KITTITAS COUNTY COMMUNITY DEVELOPMENT SERVICES

October 1, 2008

Kittitas County Community Development Services has determined that the Goebel Short Plat (SP-08-00030) is a complete application and hereby grants **conditional preliminary approval** subject to the following conditions:

**GOEBEL SHORT PLAT  
 PART OF SECTION 2, T. 19 N., R. 15 E., W.M.  
 KITTITAS COUNTY, WASHINGTON**

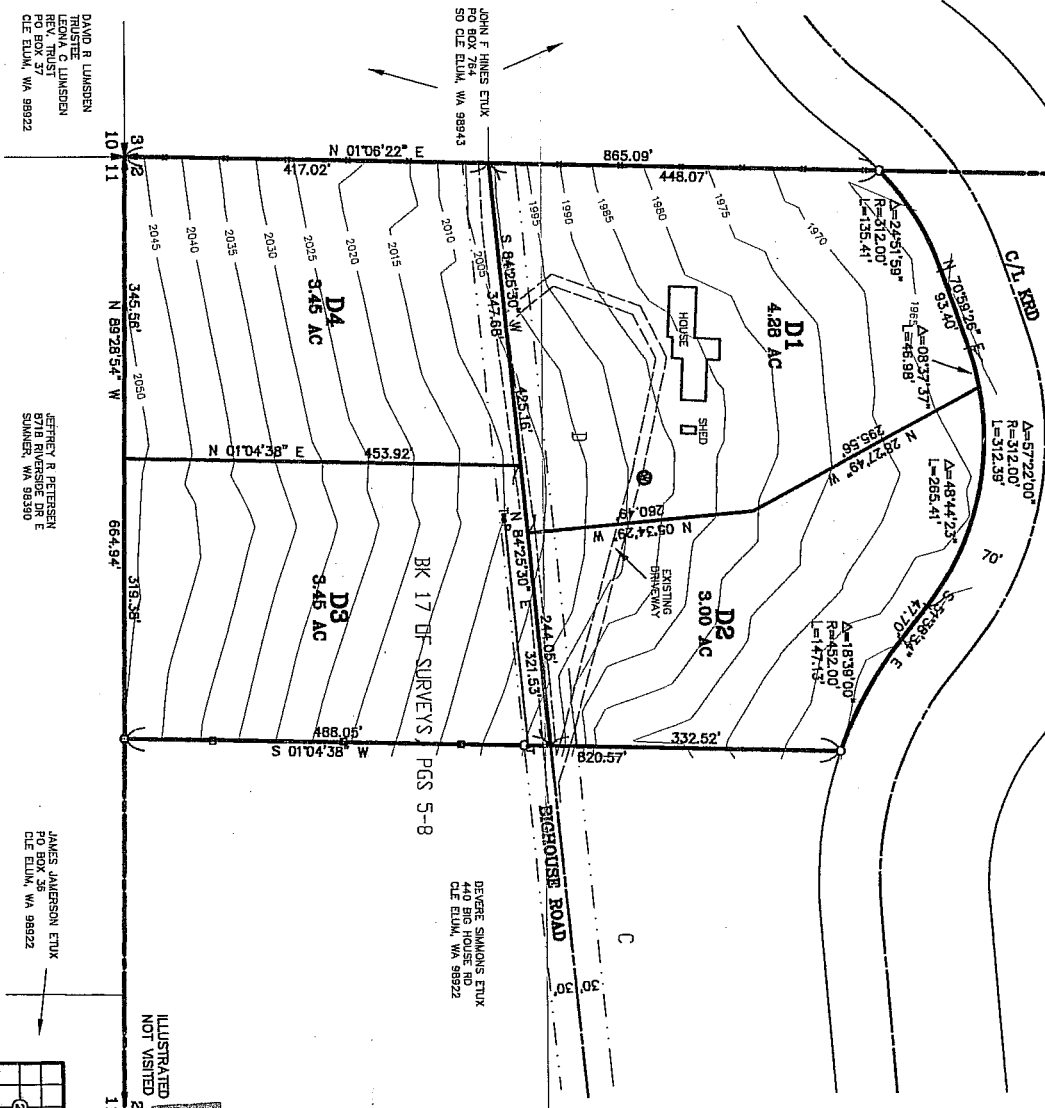
1. Both sheets of the final mylars shall reflect short plat number (SP-08-00030) and an accurate legal description shall be shown on the face of the final plat.

8. Per Kittitas County Environmental Health, soil logs need to be performed and a well log is needed for the existing well on lot D1. Evidence of both shall be provided to Community Development Services prior to final approval.

10. Turnaround: A temporary hammerhead or cul-de-sac turnaround shall be constructed at the western lot boundary and shown on the final plat. The temporary cul-de-sac turnaround shall have an outside right-of-way easement diameter of at least 110 feet and when constructed, the driving surface shall be at least 96 feet in diameter. The temporary easement may be abandoned when the road is extended. Hammerheads and cul-de-sacs must also conform to the requirements specified by the 2006 International Fire Code. Contact the Fire Marshal regarding any additional cul-de-sac requirements.

11. Private Road Improvements: Access from Upper Peoh Point Road to the turnaround shall be constructed as a Low-Density Private Road. See Kittitas County Road Standards, 9/6/05 edition.

- a. Access easements shall be a minimum of 60' wide. The roadway shall have a minimum width of 20', with 1' shoulders, for a total width of 22'.
 - b. Minimum centerline radius will be 60'.

- c. The surface requirement is for a minimum gravel surface depth of 6".
 - d. Maximum grade is 12%.
 - e. Stopping site distance, reference AASHTO.
 - f. Entering site distance, reference AASHTO.
